# CITY OF ALBUQUERQUE

RE: **Hurt Residence, Lot 11, Block 5 Unser Cliffs**  
**Grading and Drainage Plan**  
**Engineer's Stamp Date 10-1-14 (File: E10D025)**

**RE: Hurt Residence, Lot 11, Block 5 Unser Cliffs  
Grading and Drainage Plan  
Engineer's Stamp Date 1-22-15 (File: E10D025)**

**RE: Hurt Residence, Lot 11, Block 5 Unser Cliffs  
Grading and Drainage Plan  
Engineer's Stamp Date 7-7-14 (File: E10D025)**

|  | <p>GRADING AND DRAINAGE PLAN</p> | <p>DATE 07-06-2014</p> |

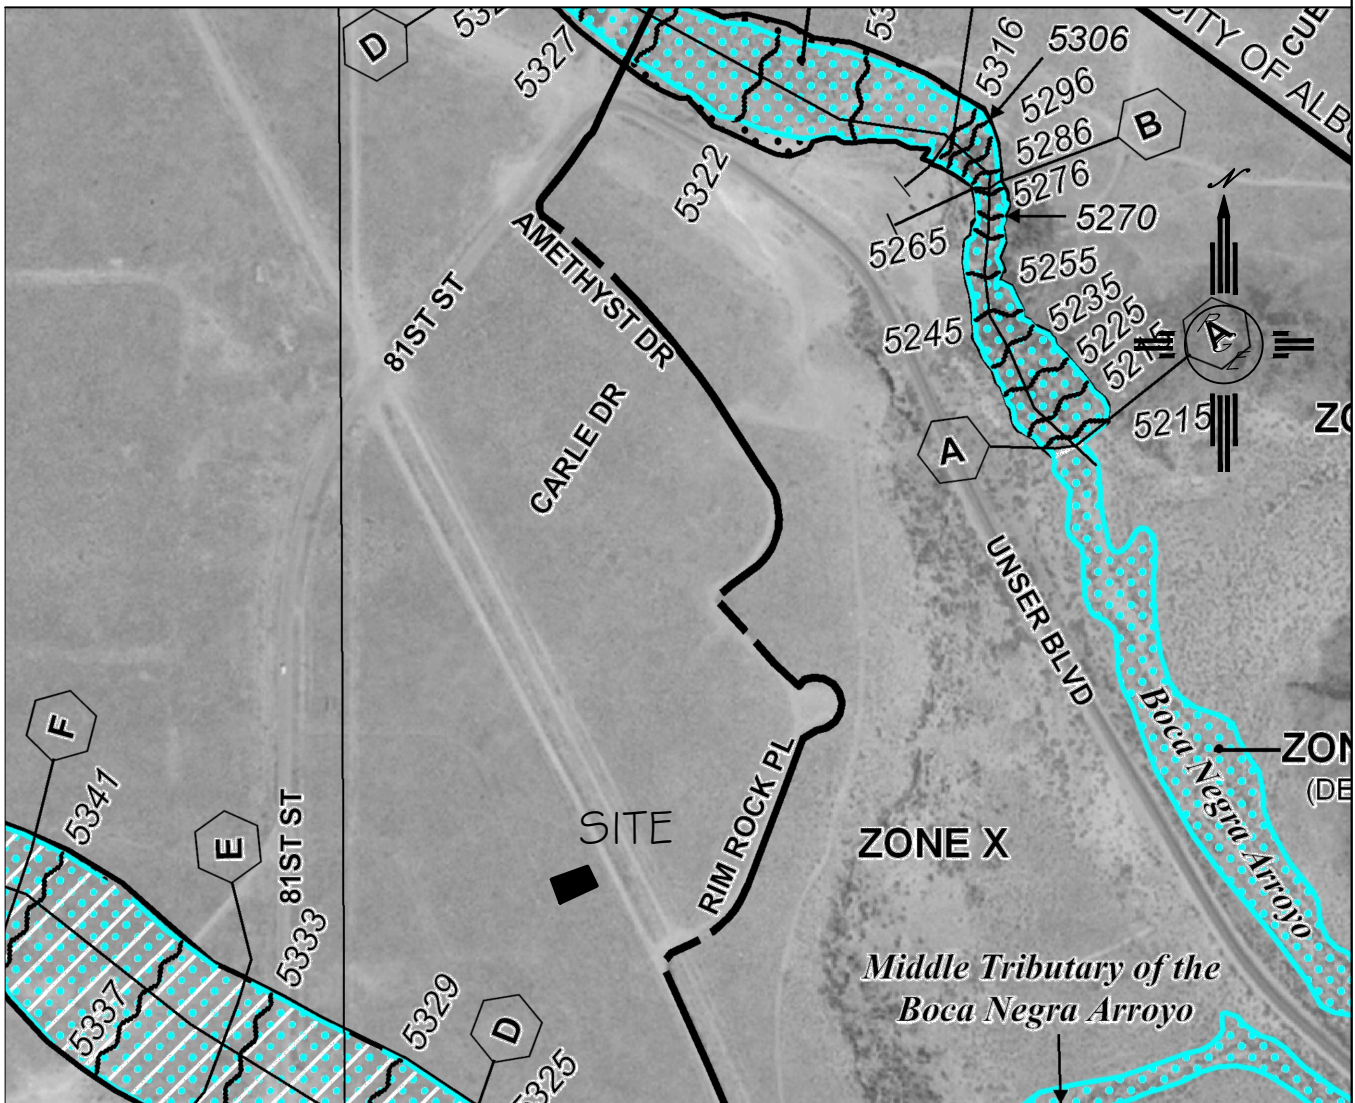
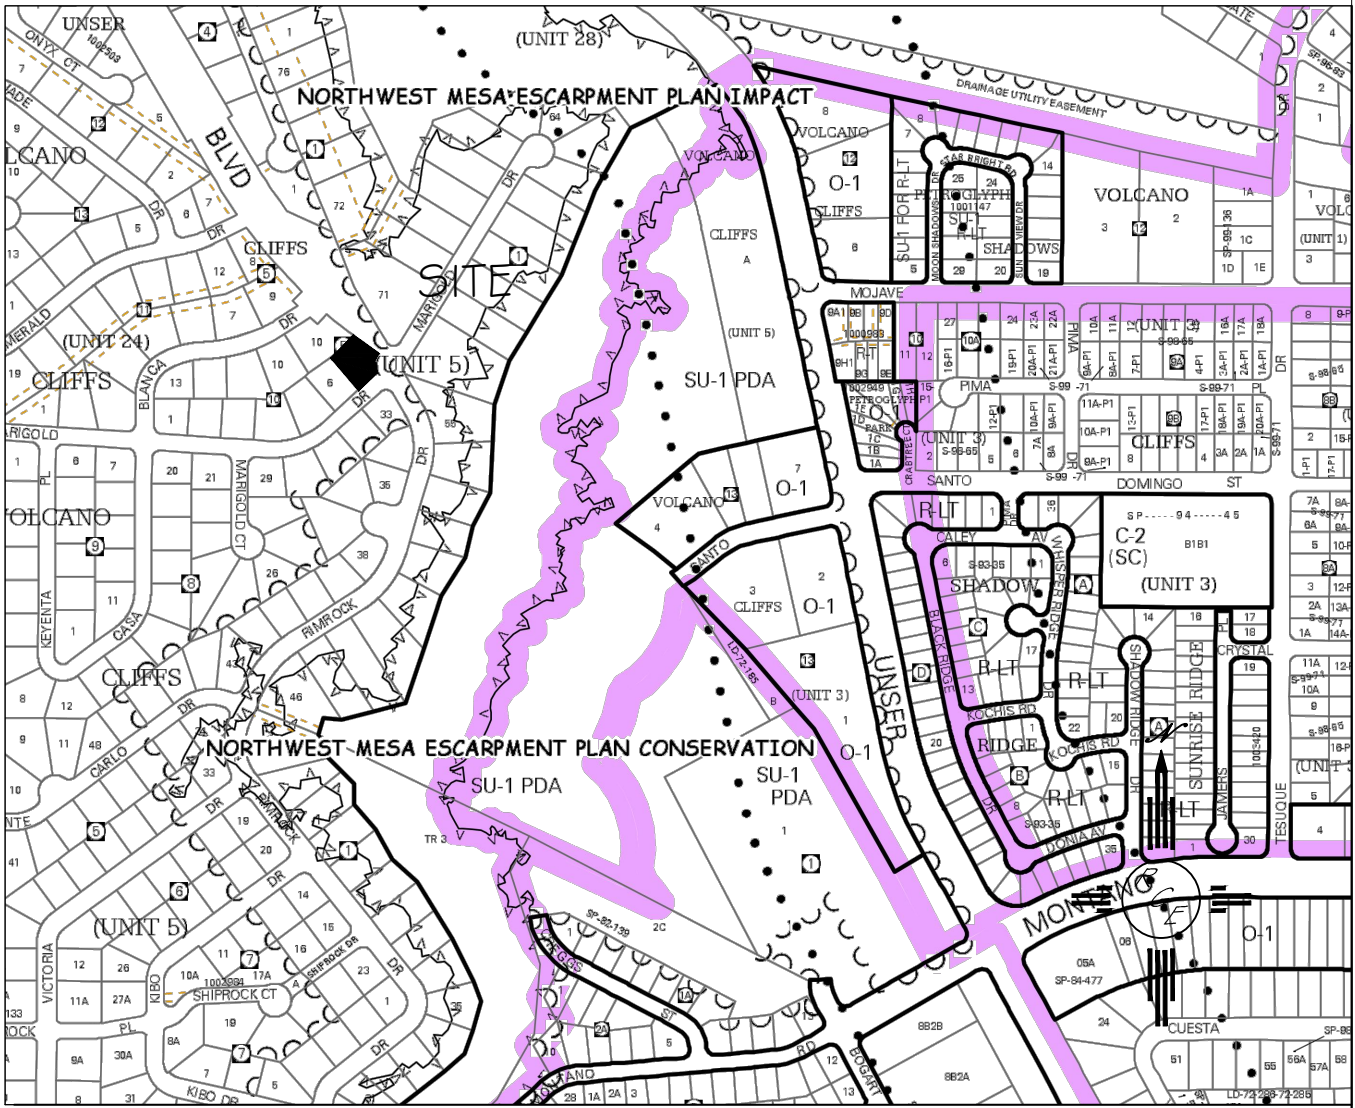
Development in SAD 227 is to comply with the **SAD 227, Unser Boulevard Middle Section Drainage Report** (Wilson & Co, 2003) which states: "an architectural review committee for the property owners association will control and monitor the lot development". Therefore the **SAD 227 Development Guidelines** are enforced by the architectural review committee, and includes the Grading and Drainage guidelines. In general, the Guidelines allow for cross-lot drainage and the downstream properties are to carry the flow to the street. Cut and fill is to be kept to a minimum.

Based upon the information provided in your submittal received 9-30-14, this lot discharges runoff to public ROW/easements and not into adjacent lots, and does not require a formal review from hydrology. Since a Grading and Drainage plan has been submitted, Hydrology has reviewed the submittal anyhow. Based upon our review, the above referenced plan is approved for Building Permit. Please attach a copy of this approved plan in the construction sets when submitting for a building permit.
